East Anglia ONE North Offshore Windfarm

Appendix 8.1 Marine Water and Sediment Quality Consultation Responses

Applicant: East Anglia TWO Limited
Document Reference: 6.3.8.1
SPR Reference: EA1N-DWF-ENV-REP-IBR-000345_001 Rev 01
Pursuant to APFP Regulation: 5(2)(a)

Table A8.1.1 Consultation Responses Related to Chapter 8 Marine Water and Sediment Quality

### Location of Sediment Contamination Sample Sites

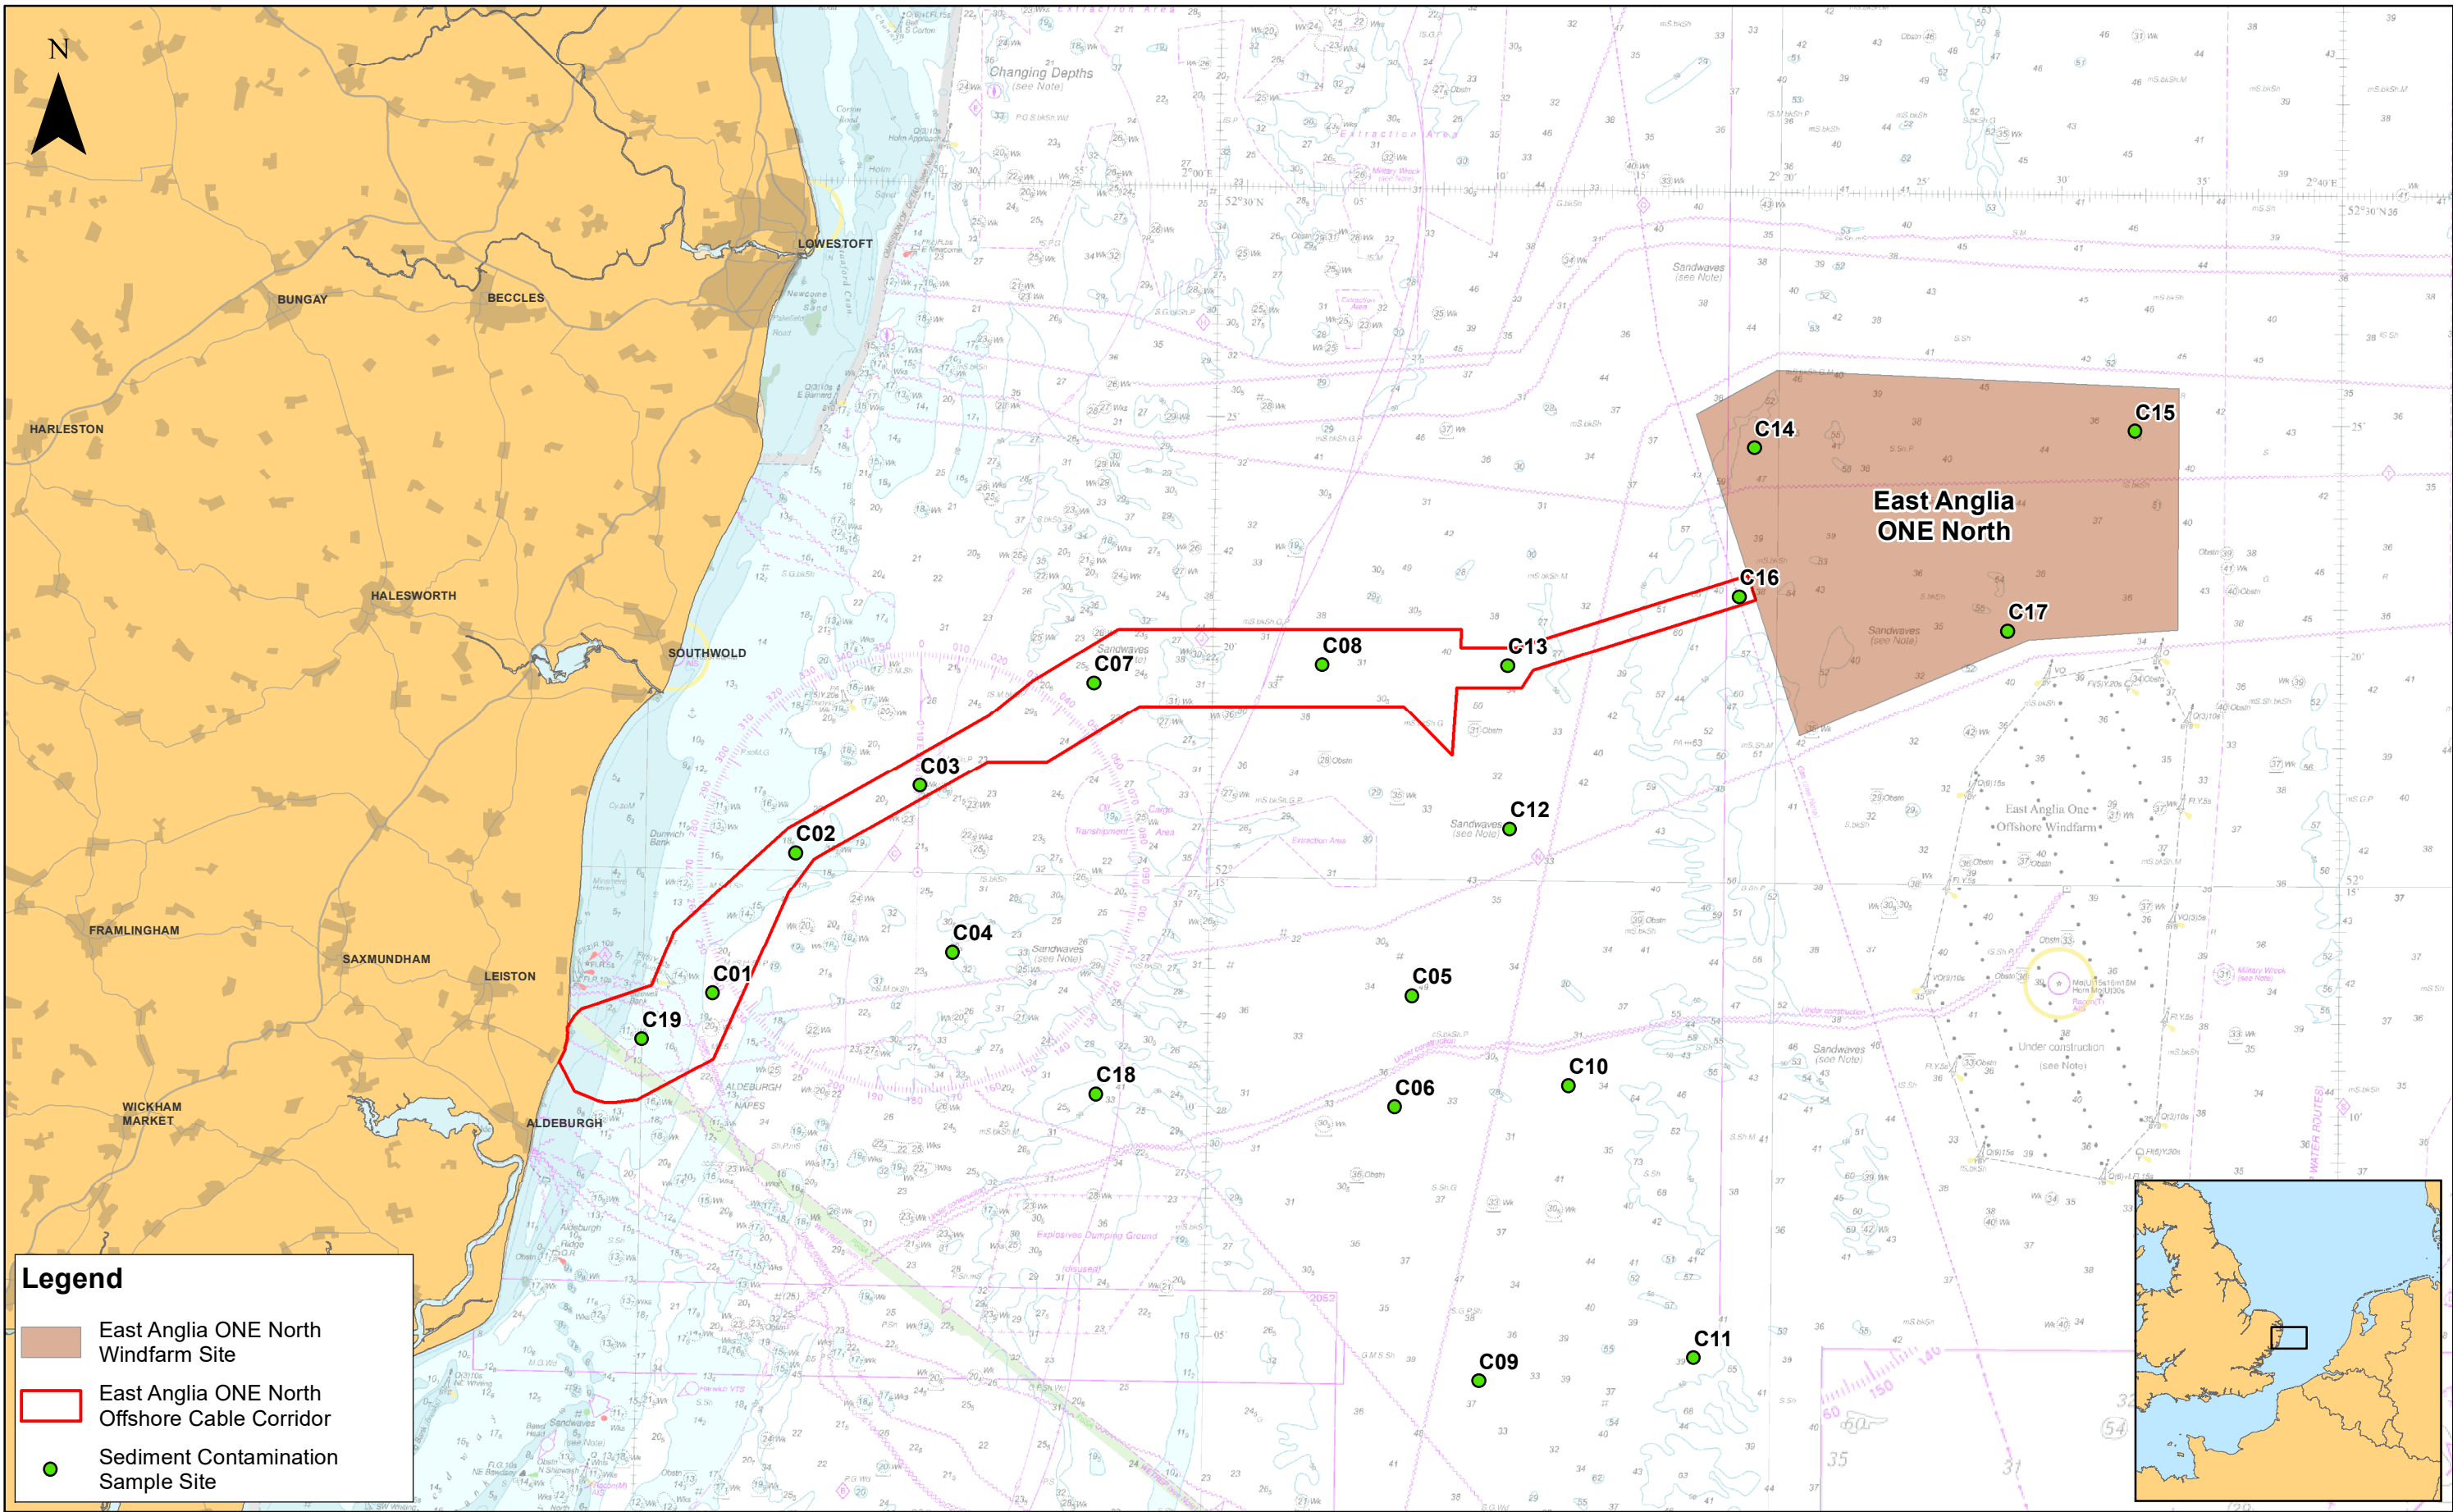
Natural England	22/03/2019	Three sample locations (C05, C07 and C16) exceed the more stringent Canadian Probable Effect Levels (PELs) for arsenic. Although SPR asserts that these elevated levels of arsenic are typical of the region, and do not exceed CEFAS Action Level 2, a concentration above PEL proposes “adverse effects may be expected in a wider range of organisms.” Does SPR consider there	It is acknowledged in section 8.4.3 of this chapter that the Canadian sediment quality guidelines are more stringent than Cefas Action Levels.

Consultee	Date/ Document	Comment	Response / where addressed in the ES
		is an elevated risk in these areas from the adverse effects from arsenic?	The potential impact of the remobilisation of contaminated sediments on benthic receptors is assessed in section 9.6.1.3 of Chapter 9 Benthic Ecology . The potential impact was assessed as negligible. Therefore, it is not considered that there is an elevated risk.
Natural England	26/03/2019	8.6.1.1. Para. 105 bullet point 2 (EA2 and EA1N) Is there an opportunity to organise drilling so plumes do not interact at all?	No significant impacts are predicted; therefore this is not considered to be necessary. The assessment (section 7.6.1.1.1) in Chapter 7 Marine Geology, Oceanography and Physical Processes concluded no likely cumulative effect from plumes interacting due to plumes not persisting in the water column for a sufficiently long time. Modelling was undertaken conservatively with all sediment being dispersed, whereas in actual fact it is likely larger clasts will settle rapidly (section 8.6.1.2 of this chapter).
